**RE: RESPONSE TO SUBMISSIONS – SSD 10470
PROPOSED WAREHOUSE AND DISTRIBUTION CENTRE
11 & 13 PERCY STREET, AUBURN**

On behalf of Fabcot Pty Ltd (the Applicant), we write to the NSW Department of Planning, Industry and Environment (DPIE) regarding your request for Response to Submissions (RTS) dated 26 November 2020, which relates to State Significant Development (SSD) Application – **SSD 10470** – at 11 and 13 Percy Street, Auburn.

Project
**PROPOSED WAREHOUSE DARK STORE
11-13 PERCY STREET, AUBURN NSW**
Title
OSD TANK PLAN, SECTIONS AND DETAILS

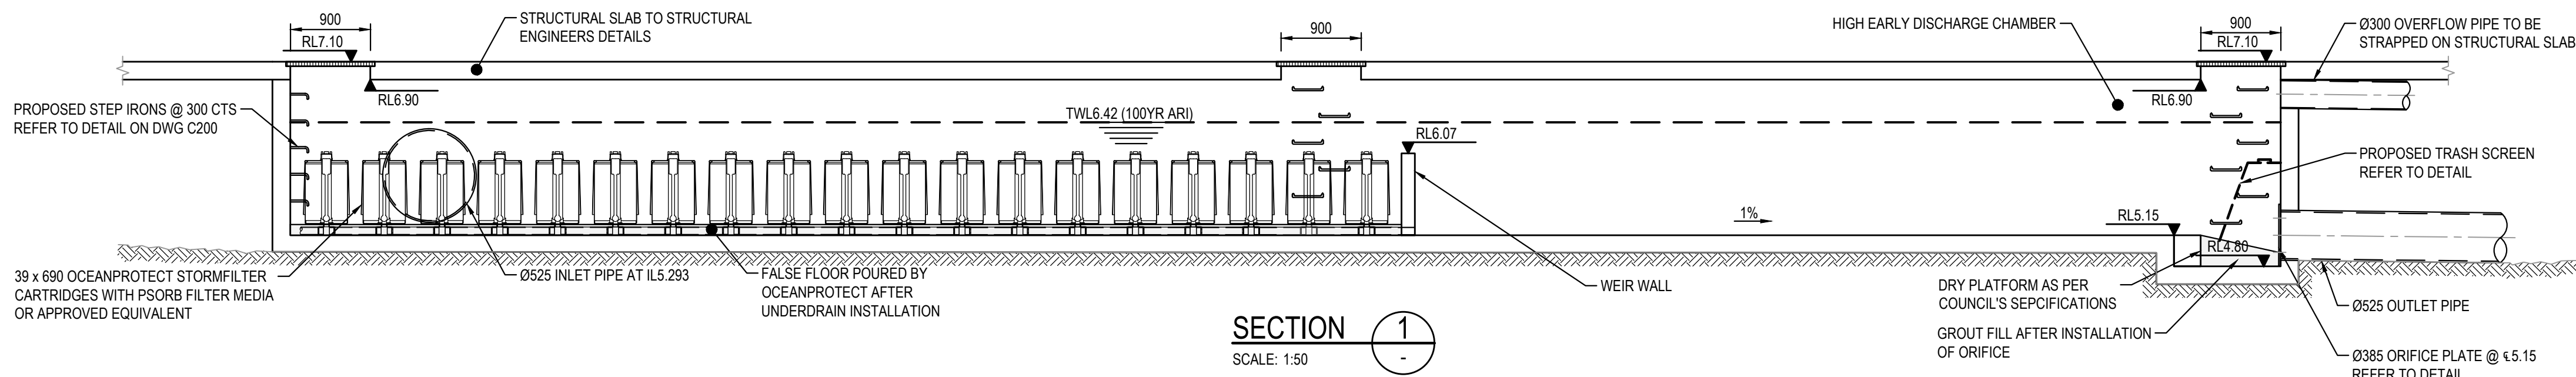
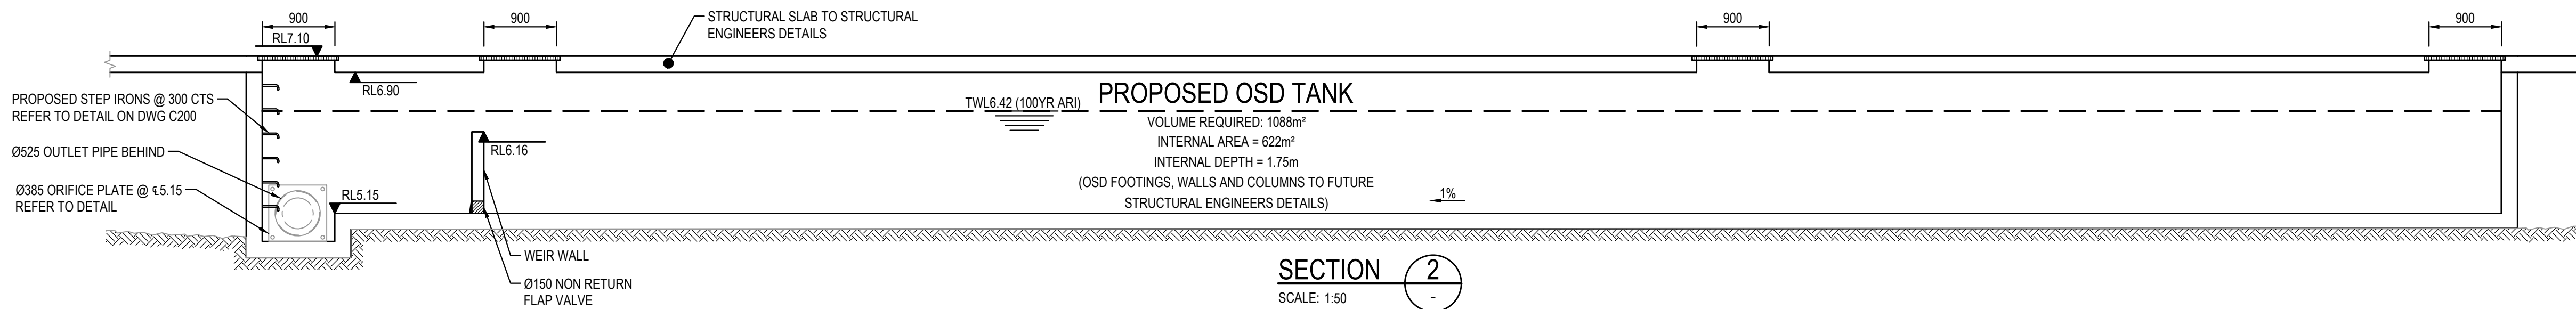
The proposed OSD tank is located below the 1% AEP flood and will not perform as per the submitted OSD calculation. The design shall be reviewed.	The proposed OSD has been moved toward the rear of the site, to drain to Haslams Creek.
		Stormwater shall be discharged to Haslam Creek subject to Sydney Water approval. Stormwater disposal to Percy Street is not acceptable. Percy Street frontage is affected by 1% AEP flood as per the survey and the ground level car parking spaces are located below the flood level.	The car park should be located above 1:20 year ARI plus freeboard. Henry & Hymas do not expect any flooding from Percy Street in 1:20 year ARI. The flooding along Percy Street in 1:100 year ARI is caused by the existing stormwater infrastructure and the existing pipe that connects with Haslams Creek. The proposed redevelopment and existing levels also have levels along the front boundary that ensure no spilling will occur from the road into the subject site. Since the spilling of flood water is prevented in the largest storm (1:100), it is assumed that there will be no risk of flooding even for smaller events such as 1:20 year ARI. The existing development at 11 Percy Street, currently discharges the stormwater to Percy Street, through 1 x 400mm pipe and few 225 pipes. That is approximately 1.1 ha that will be discharged from the OSD to Haslams Creek, which will significantly improve the flood situation along Percy Street.
